**Application by Highways England for the M25 Junction 28 improvement scheme (the Proposed Development)**  
**The Examining Authority's Written Questions and Requests for information (WQ1)**  
**Issued on Wednesday 13 January 2021**

**Responses are due by Deadline 2: Thursday 4 February 2021**

Project Title		M25 Junction 28	
Drawing Title		FIGURE 5.8 AIR QUALITY RECEPTORS	
Drawing Number		HE551519 - ATK - EAQ XX - GS - GI - 000008	
Original Size: A3	Scale: 1:7,500	Project Ref. No: --	Sheet: 1 of 1 Rev: C01

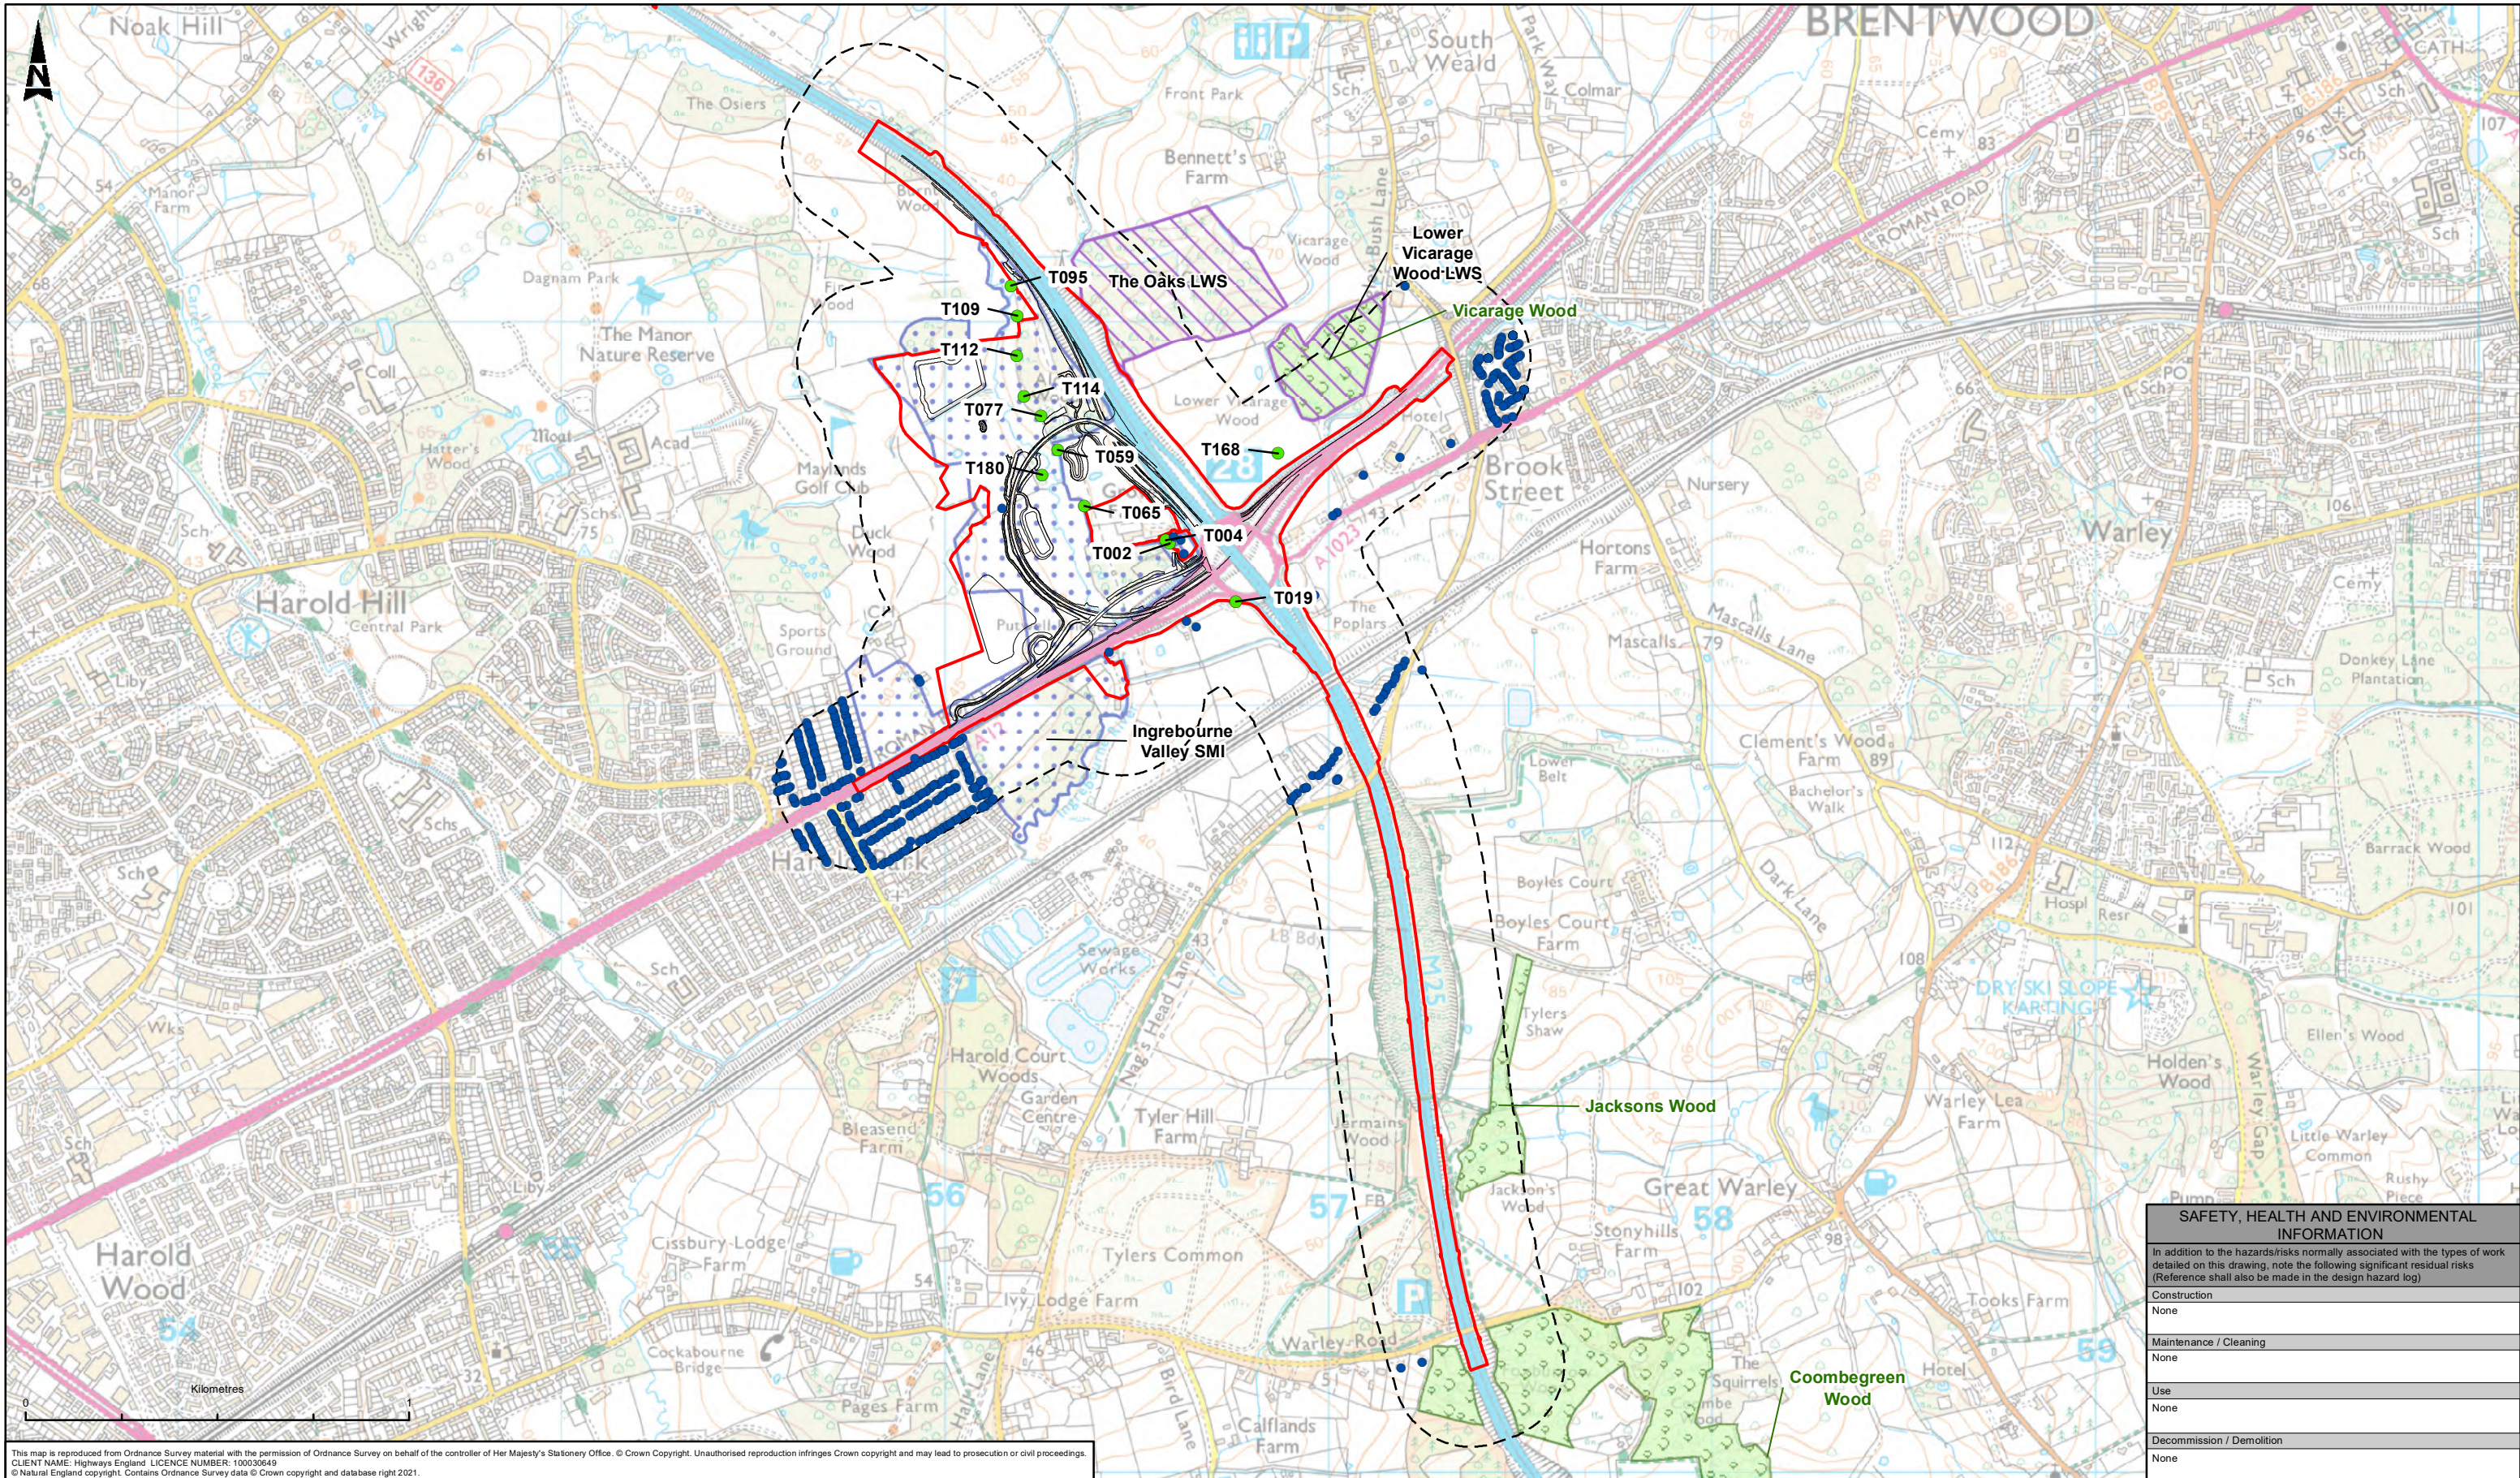
AQ 1.6	<p><i>Methodology</i> <b>The Applicant</b></p>	<p>Air quality modelling has been undertaken based on IAN 170/12 v3 and is detailed in Appendix 5.1 [APP-052]. The Applicant has not explained why the monitoring stations shown on Figure 5.1 [APP-040], especially those within the Brentwood Air Quality Management Area (AQMA) which are exceeding the nitrogen dioxide (NO<sub>2</sub>) 40ug/m<sup>3</sup> (micrograms per cubic metre) limit have not been modelled for the 2022 operation year.</p> <p>Explain why the air quality monitoring stations shown on Figure 5.1 have not been included within the air quality model for the operation year of 2022, considering these receptors are within the Havering and Brentwood AQMA's.</p>
AQ 1.7	<p><i>Methodology</i></p>	<p>Paragraph 5.7.25 of Chapter 5 of the ES [APP-027] states that Maylands Golf Club will be included as a receptor, and Maylands Golf Club is stated to be receptor R79 in Table</p>

<b>The Applicant</b>	<p>5.1 of the Air Quality Appendix [APP-052]. However, R79 does not appear on Figure 5.8 [APP-040]. Moreover, the coordinates stated for R79 appear to be within the Order limits of the Proposed Development, and therefore is unlikely to be an area of use by the golf club once construction has commenced. It is also noted that receptor R47 is not depicted on Figure 5.8.</p> <p>Explain the anomalies and provide the exact location of R79 and R47 on a figure which also includes the Proposed Development's Order limits.</p>
AQ 1.8	<i>Methodology</i> <b>The Applicant</b>	<p>Table 5.8 of the Air Quality Appendix [APP-052] states that R47 and R79 are selected for comparison with the 1-hour mean NO<sub>2</sub> air quality objective, and / or 24-hour mean PM10 UK National Air Quality Strategy (AQS) objective.</p> <p>Explain why these two receptors were chosen over other receptors.</p>
